## KITTITAS COUNTY COMMUNITY DEVELOPMENT SERVICES

June 25, 2010

### **RE: McMechan Short Plat (SP-09-00011)**

The Kittitas County Community Development Services Department has determined that the McMechan Short Plat (SP-09-00011) is a complete application and hereby grants *conditional preliminary approval* subject to the following conditions:

McMECHAN TRUST SHORT PLAT
PART OF SECTION 9, T. 17 N., R. 18 E., W.M.
KITITAS COUNTY, WASHINGTON

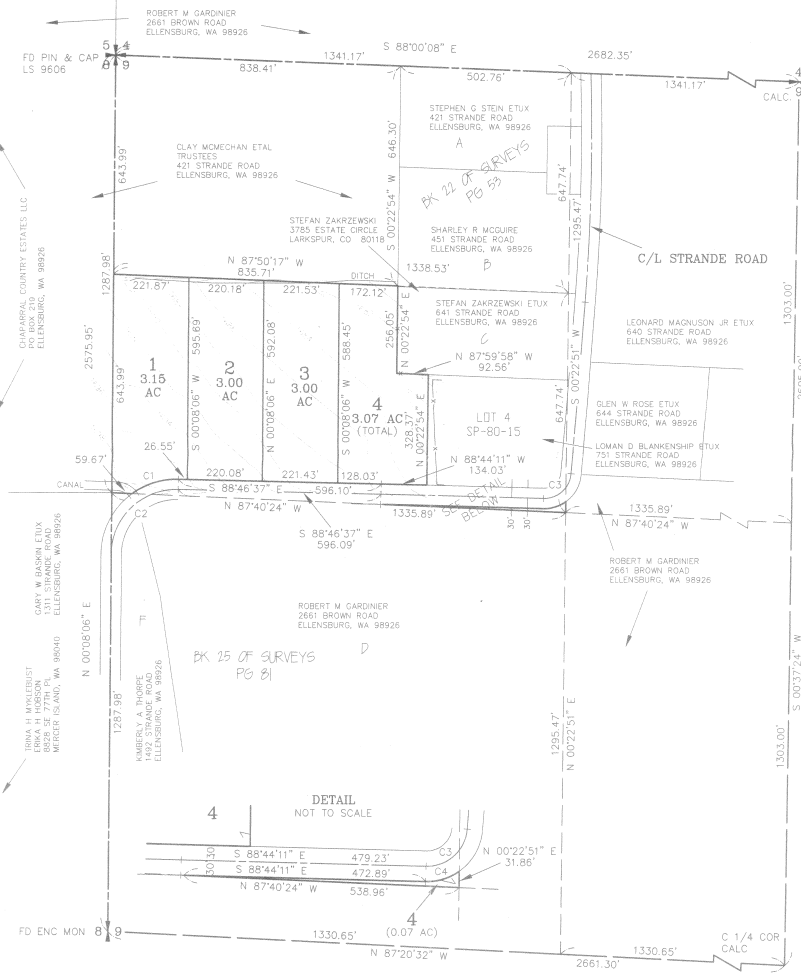
1. Both sheets of the final mylars shall reflect short plat number SP-09-00011 and an accurate legal description shall be shown on the face of the final plat.

2. Full year's taxes must be paid on all tax parcel numbers per requirement of the Kittitas County Treasurer's Office.
3. The following plat notes shall be recorded on the final mylar drawings:

- All development must comply with International Fire Code.
  - The subject property is within or near designated natural resource land of long-term commercial significance on which a variety of commercial activities may occur that are not compatible with residential development for certain periods of limited duration. (RCW 36.70A.060(1)) Commercial natural resource activities performed in accordance with county, state and federal laws are not subject to legal action as public nuisances. (RCW 7.48.305)

- The approval of this division of land includes no guarantee that there is a legal right to withdraw groundwater within the land division. The approval of this division of land provides no guarantee that use of water under the ground water exemption (RCW 90.44.050) for this plat or any portion thereof will not be subject to curtailment by the Department of Ecology or a court of law.

- Metering shall be required on all new residential well connections and metering results shall be recorded in a manner consistent with Kittitas County and Washington State Department of Ecology requirements.

- Kittitas County will not accept private roads for maintenance as public streets or roads until such streets or roads are brought into conformance with current County Road Standards. This requirement will include the hard surface paving of any street or road surfaced originally with gravel.
